Your Ref :
Our Ref : LU/234/18/NMA

Section 96A of the Town & Country Planning Act 1990 (as amended)
Town and Country Planning (Development Management Procedure) (England) Order 2015 (as amended) - Article 10

Application for non-material amendment following planning permission LU/364/17/PL relating to omission of balconies, materials & window details
The Tap And Barrel, Duke Street, Littlehampton,

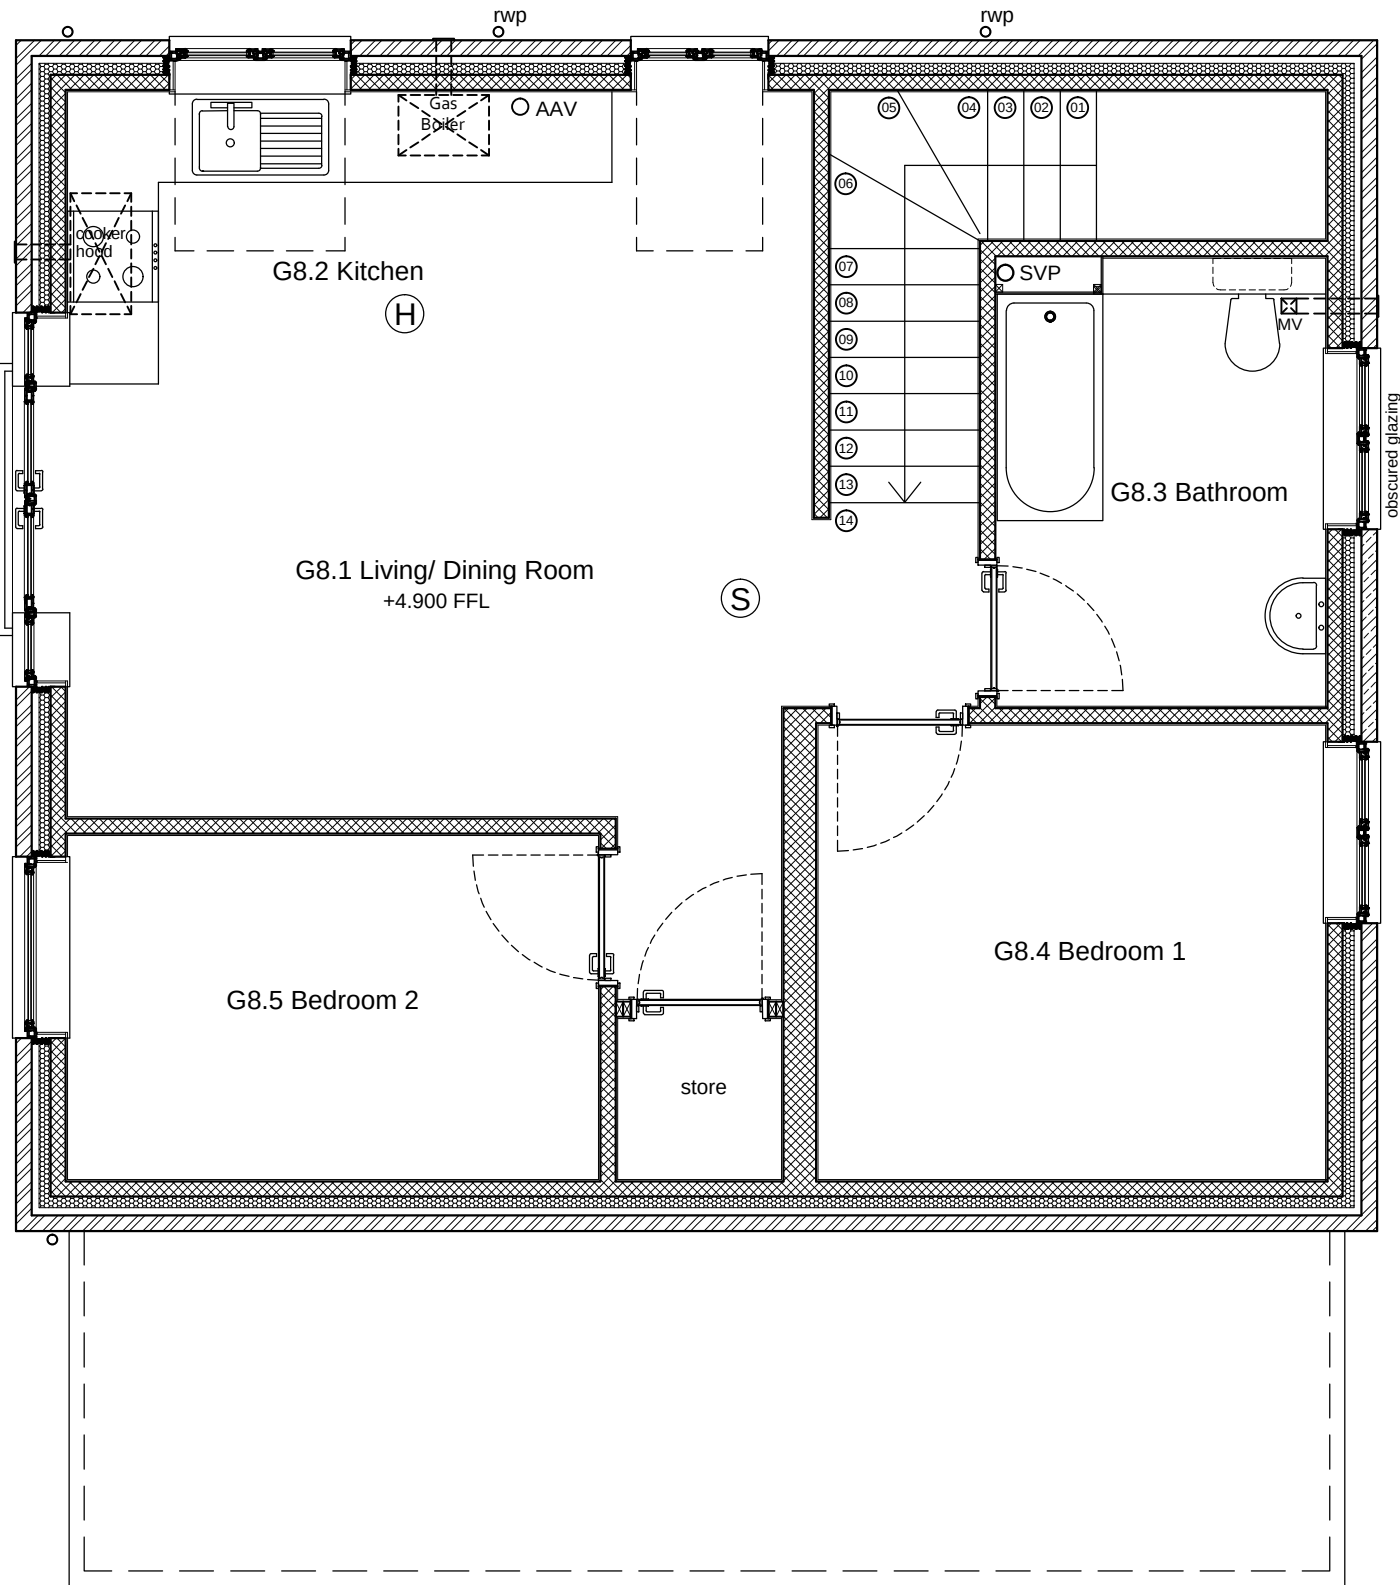
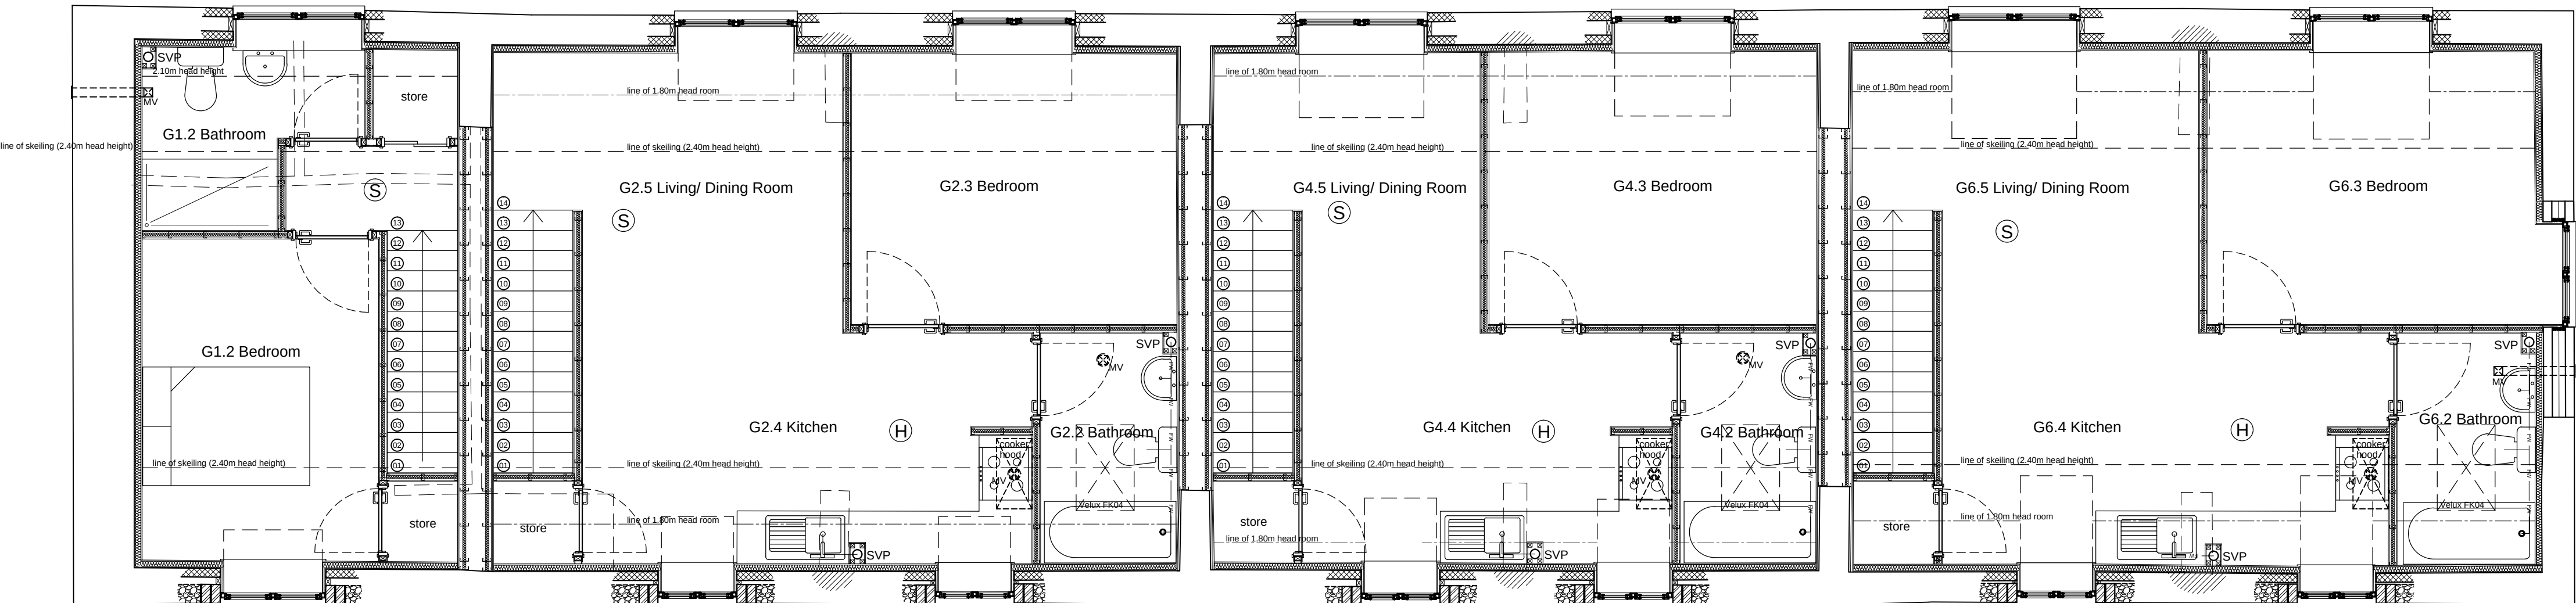
From the information submitted I am able to take the proposed alterations namely alterations to windows and doors, deletion of balconies, amendment to dormer specification, amendments to cill heights of dormers, amendment to window width to flat 1 and alterations to the roof profile as a Non Material Minor Amendment to LU/364/17/PL. The following plans have therefore become the approved elevation and floor plans for LU/364/17/PL:
